# Rezoning Transportation Analysis

Petition Number: 2022-136

Date	Description
1-25-23	First Review (TM)

RZ1

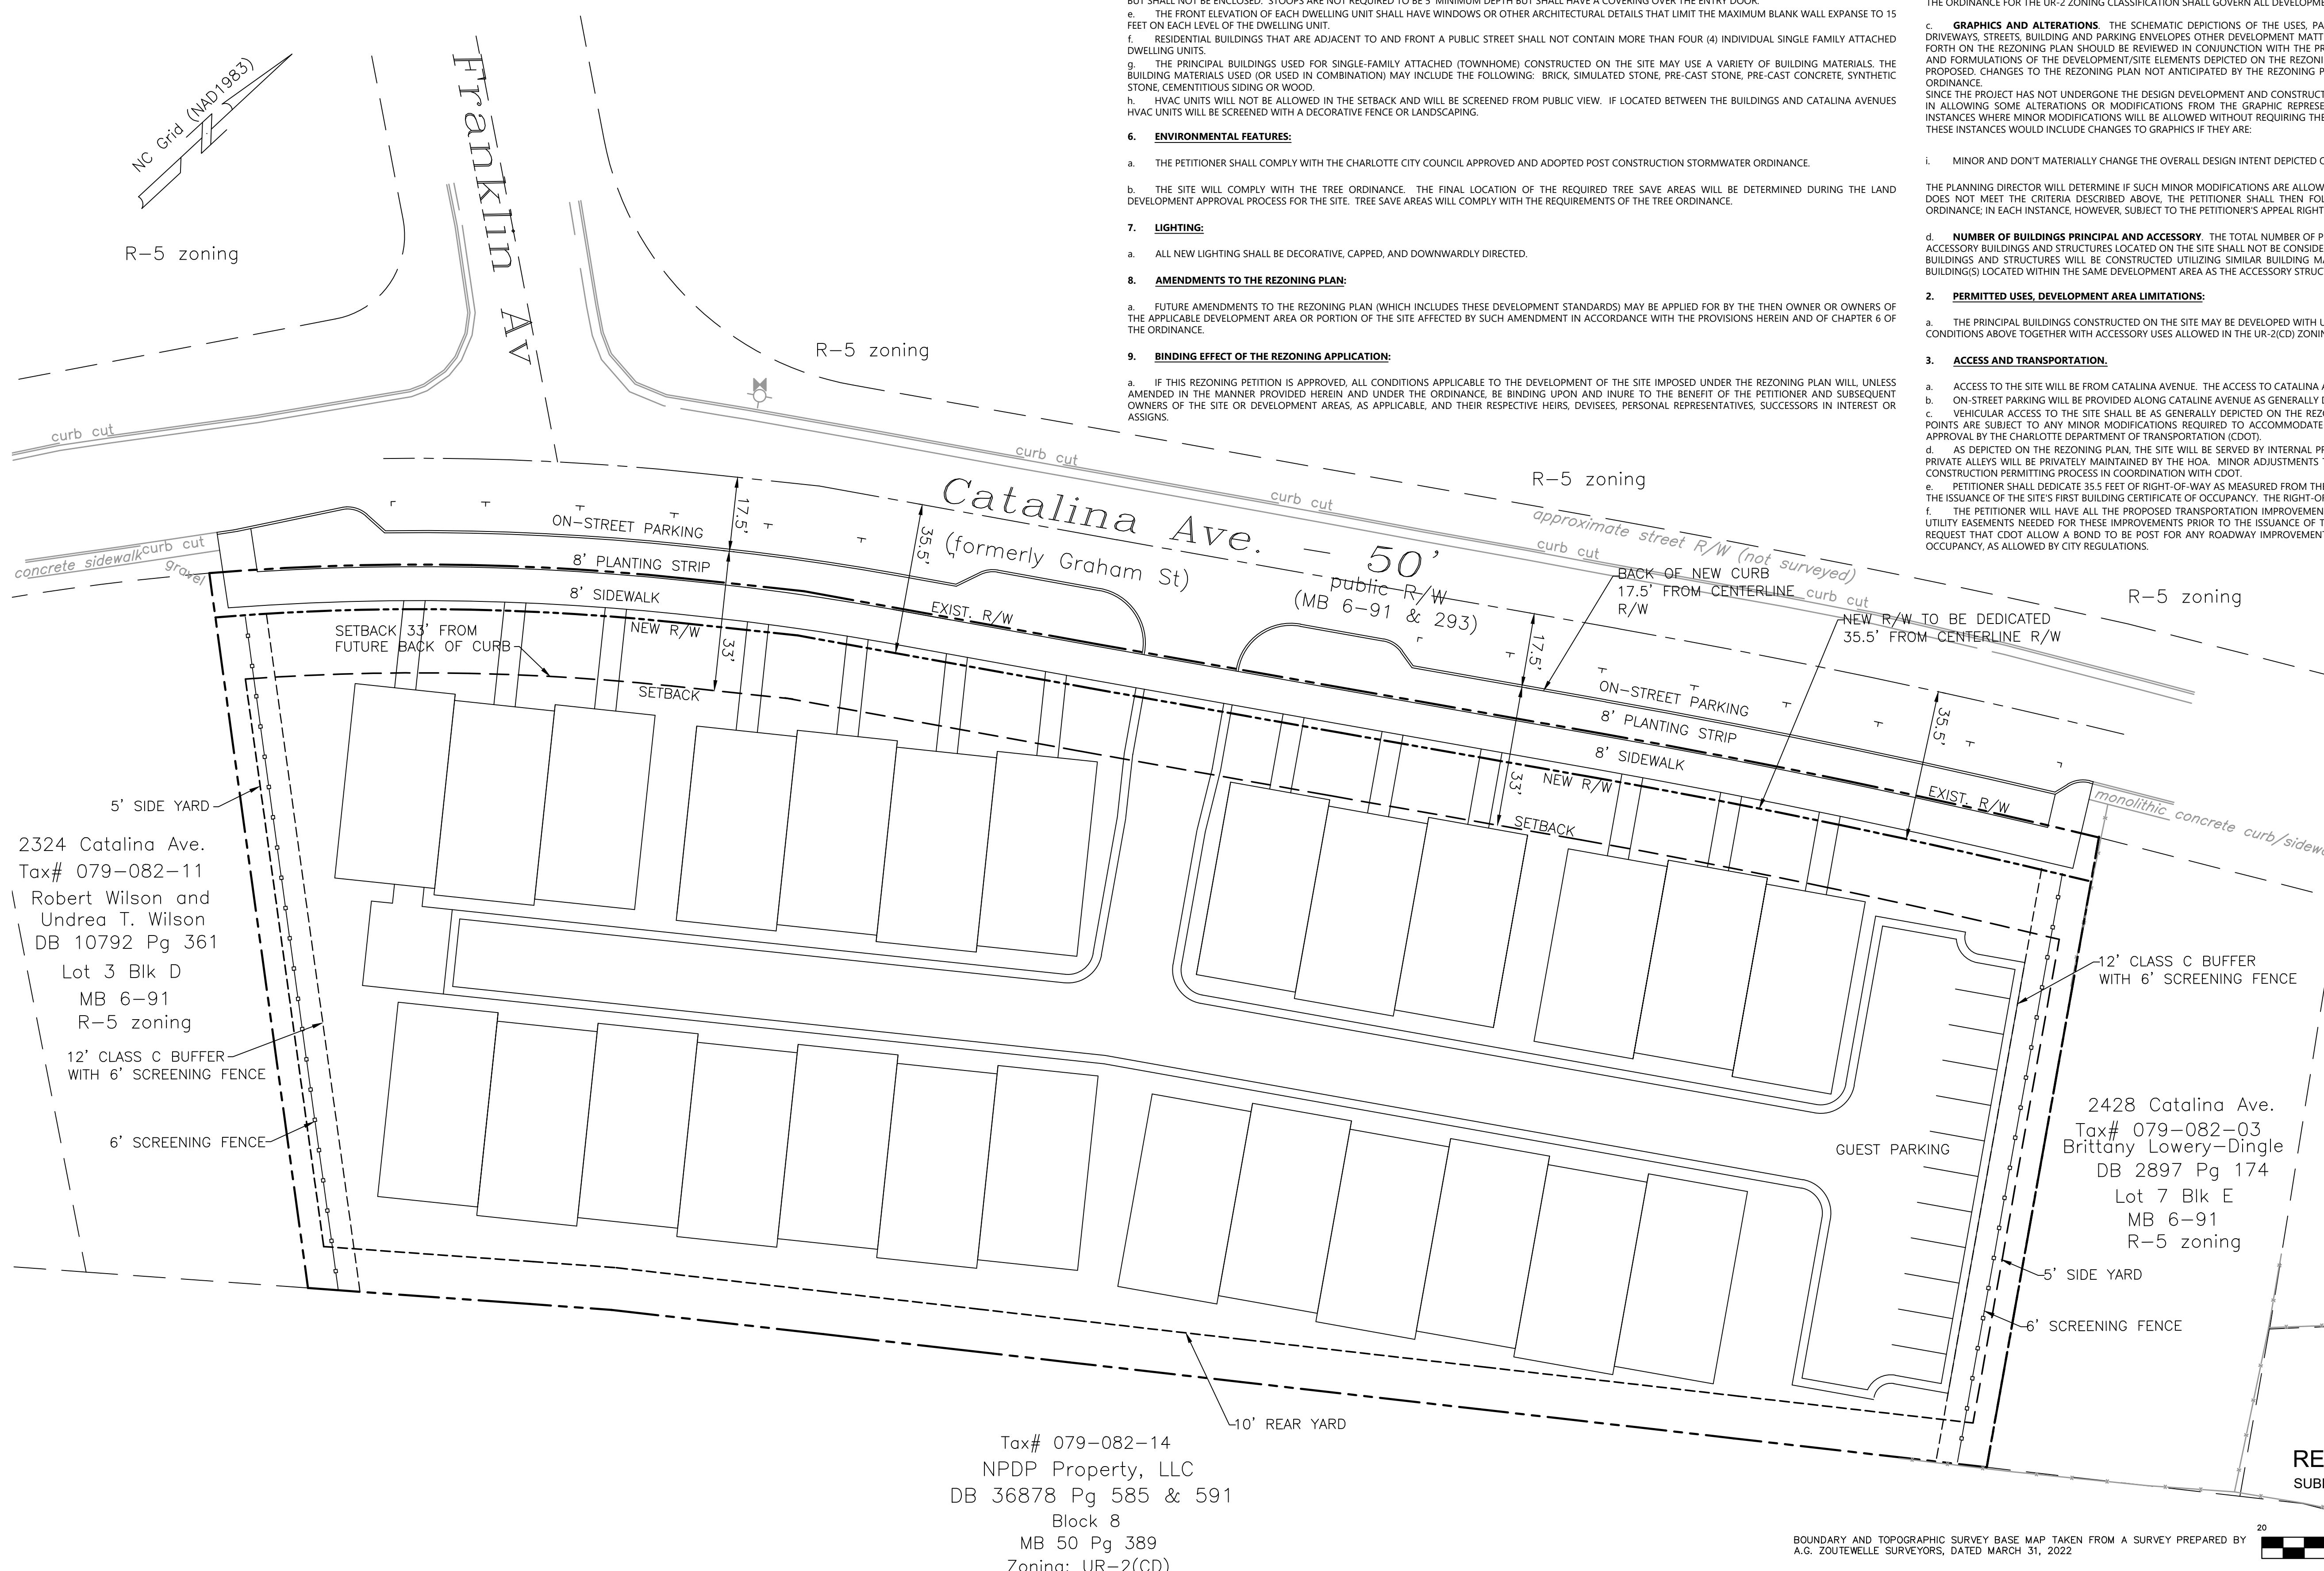
- a. **Catalina Avenue:** The future location of curb and gutter is in its existing location.

NOTE: Additional distance from center line to back of curb may be required in locations where a median is present or around intersections and interchanges.

Label and dimension the curb and gutter from the centerline for each road on the site plan.

### 3. Label internal private alleys and identify appropriate CLDSM cross section.

### 5. Revise site plan by relocating the site entrance driveway to align with Franklin Ave.
